ENG-CDR21010-R3-GEC-Vollmer-North.pdf Markup Summary

Subject: Text Box
Page Index: 1
Date: 4/11/2022 1:32:58 PM
Author: dsdrice
Color: ■
Layer:
Space:
Page Label: [1] 1 2518800 Vollmer North GESC-CV01 -
Vollmer GESC CV01

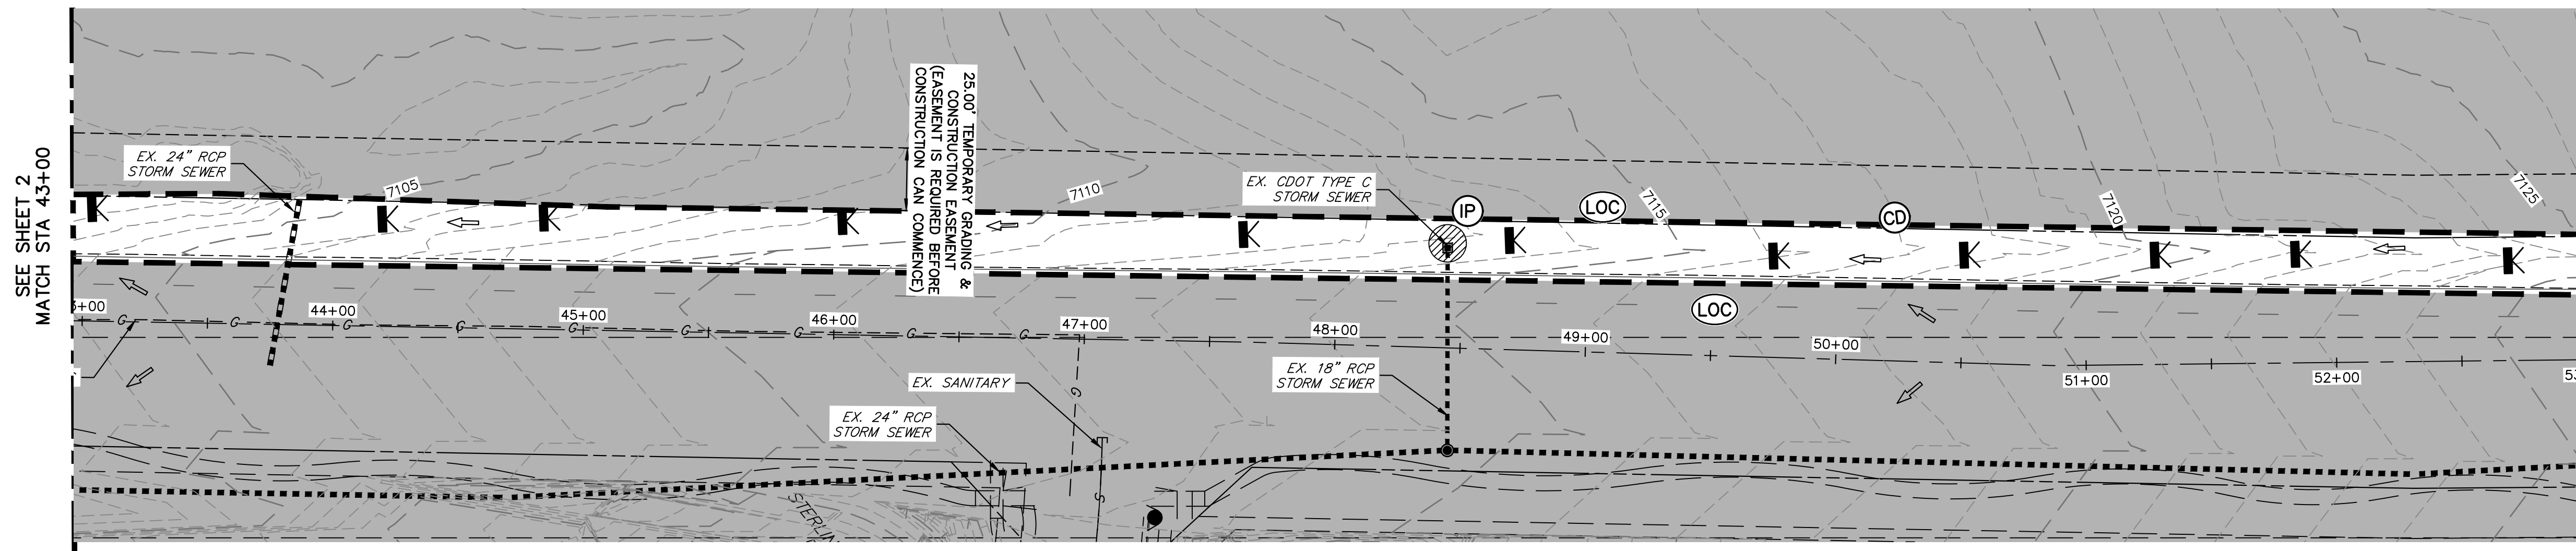
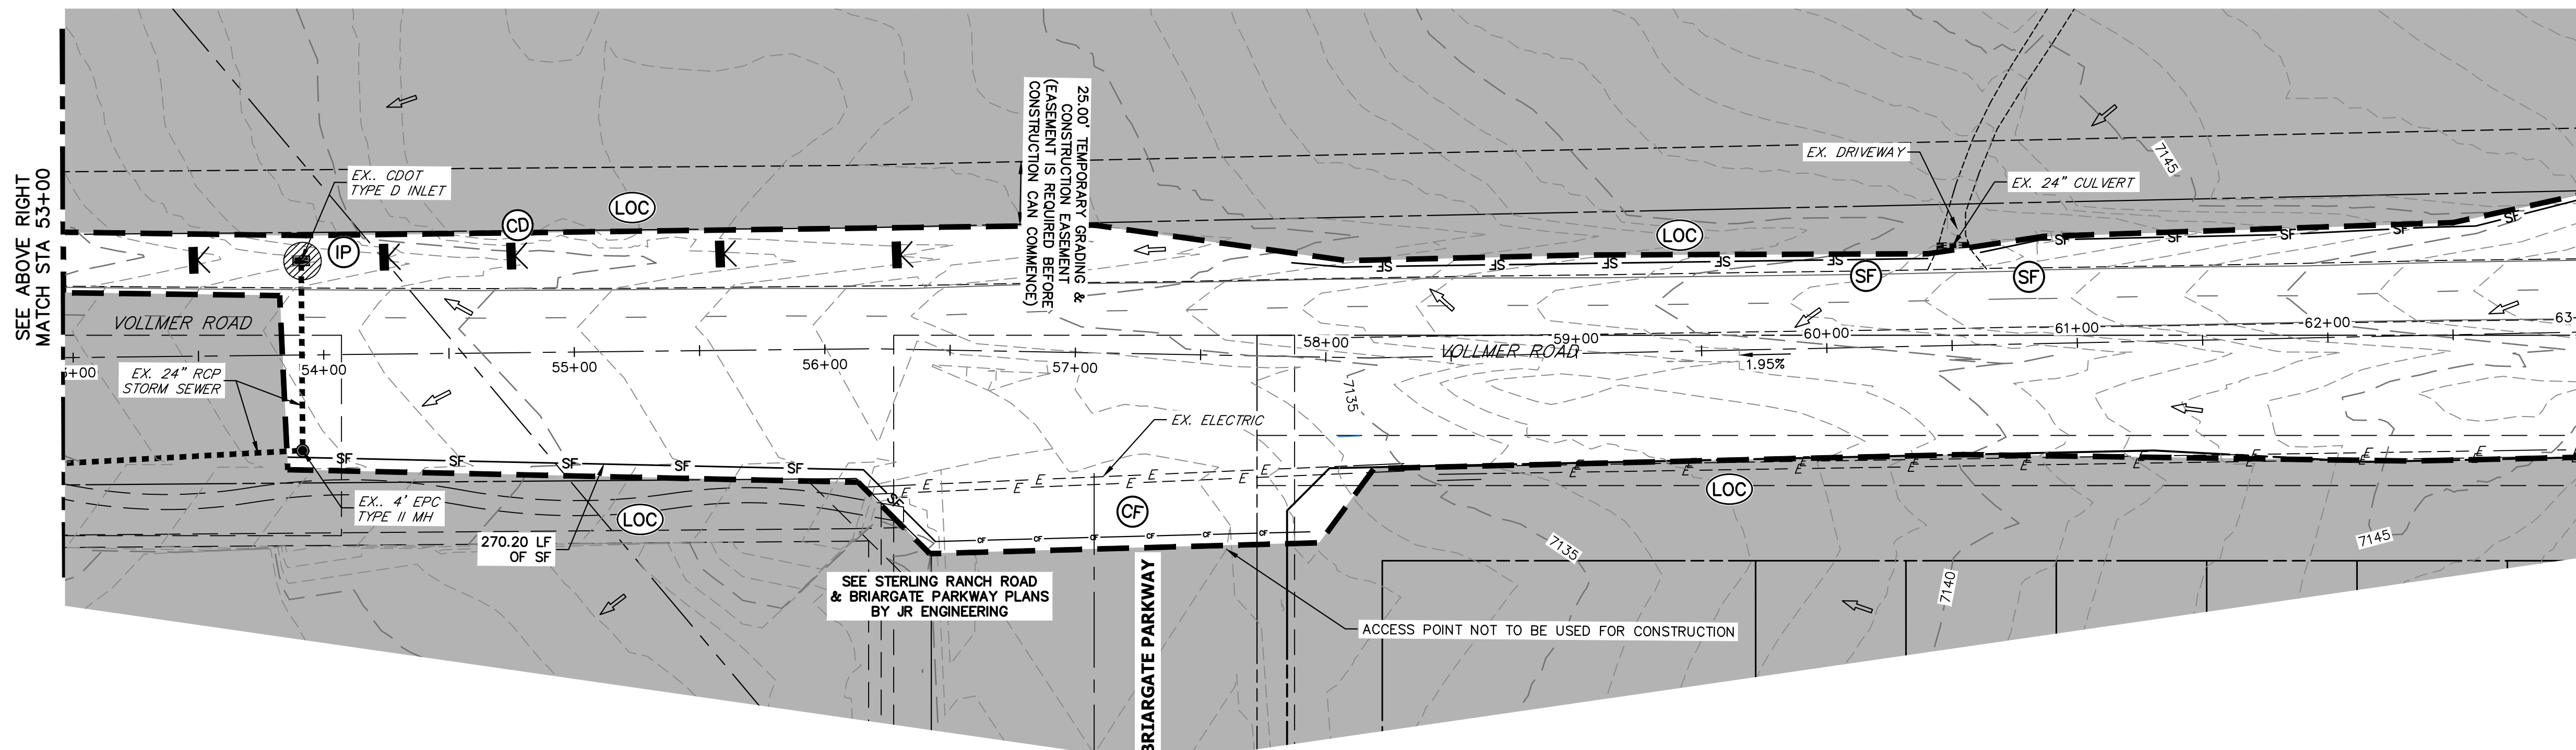
BMP in ditch?

VOLLMER ROAD (NORTH)	GRADING AND EROSION CONTROL INTERIM PLAN	DESIGNED BY	CWC
		DRAWN BY	SWW
SHEET	9	OF	16
JOB NO.	25188.00

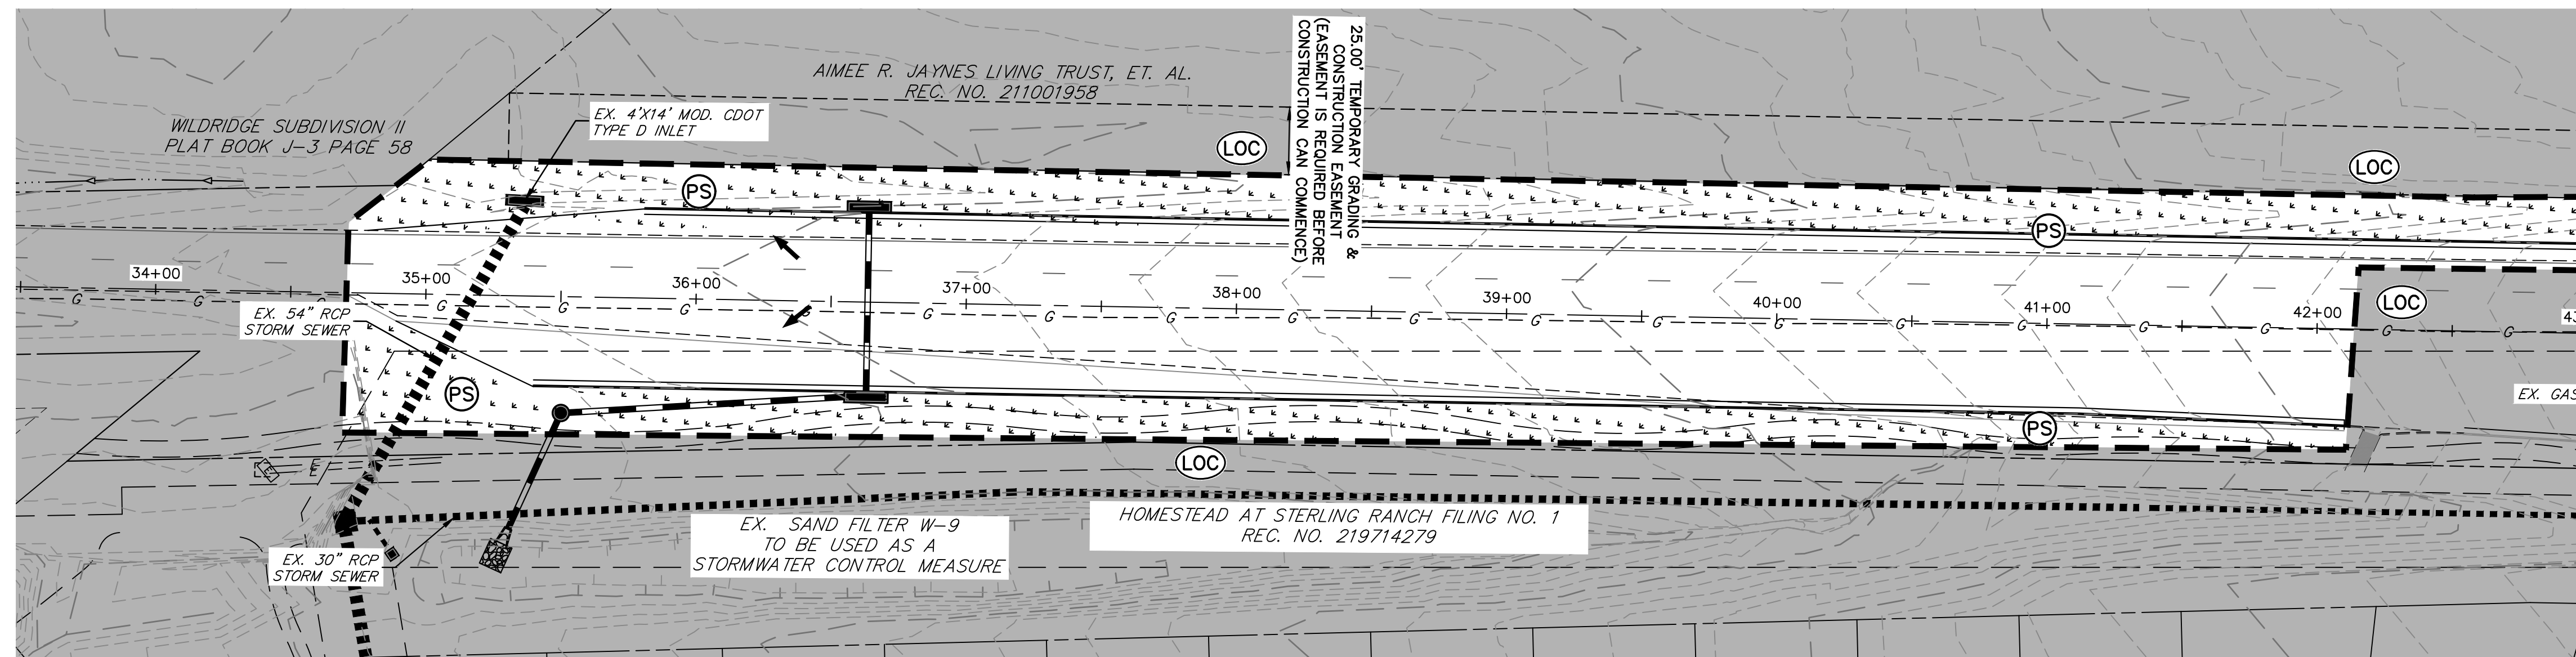
Unresolved:
Contours aren't tying in - Show all grading

Unresolved:
Verify grading per cross-sections (is a berm/double ditch needed here?)

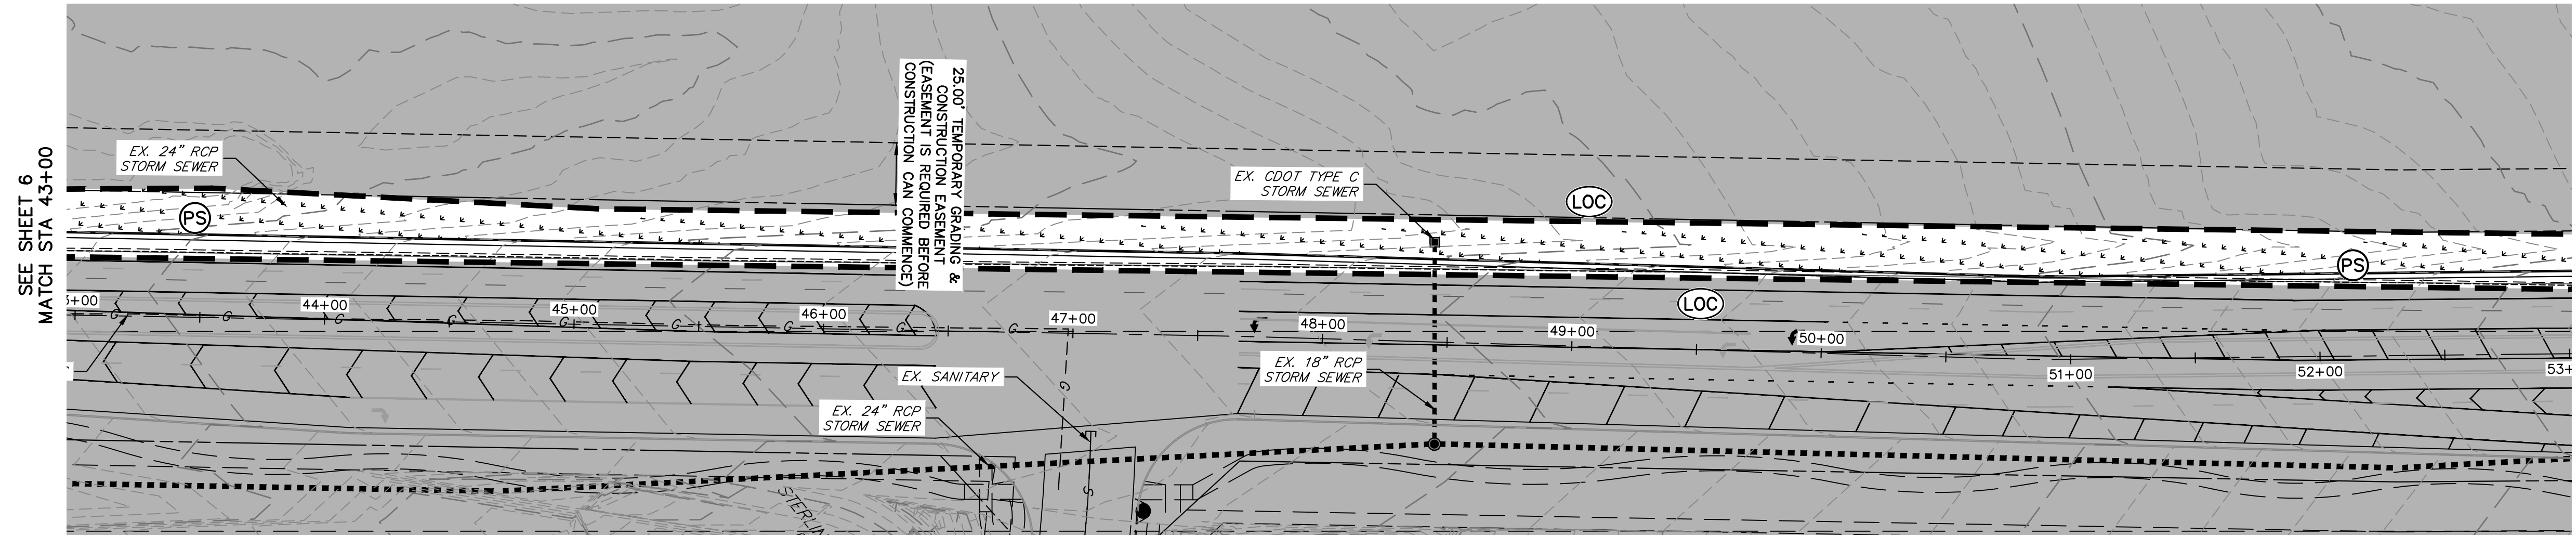
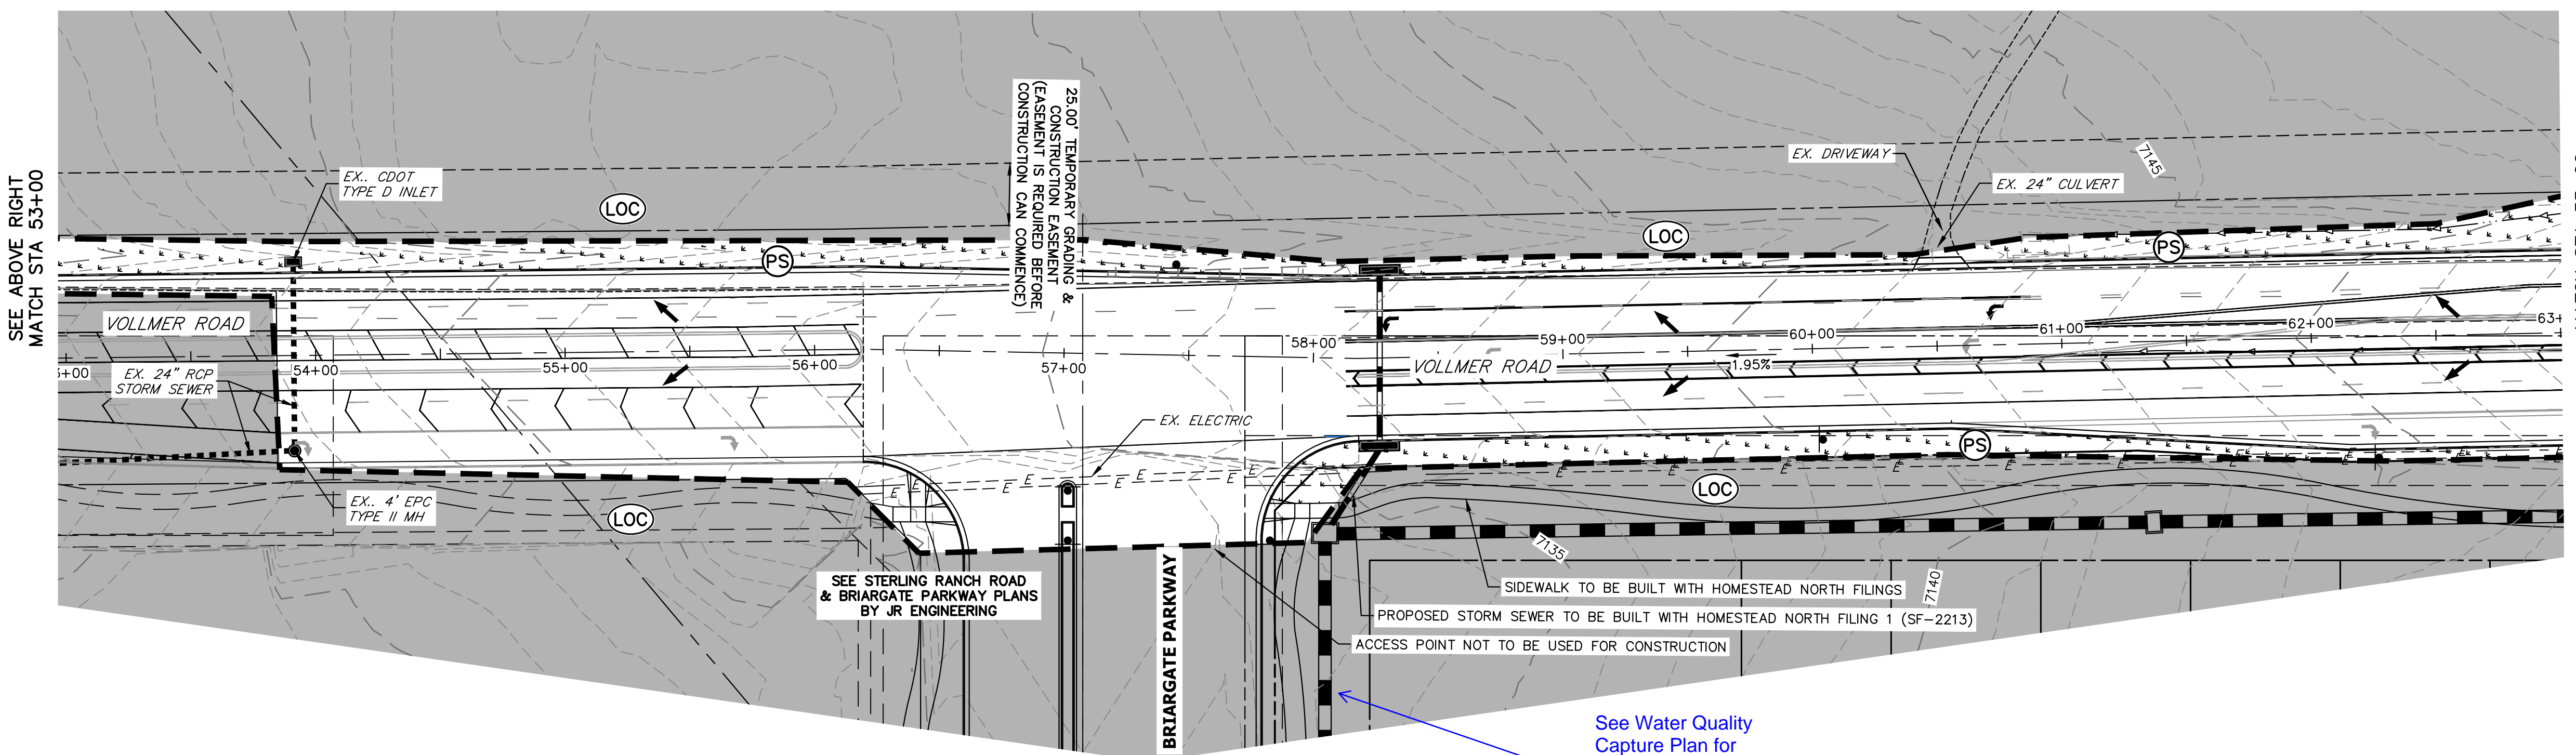
Add permanent seeding and mulching

Add parcel info
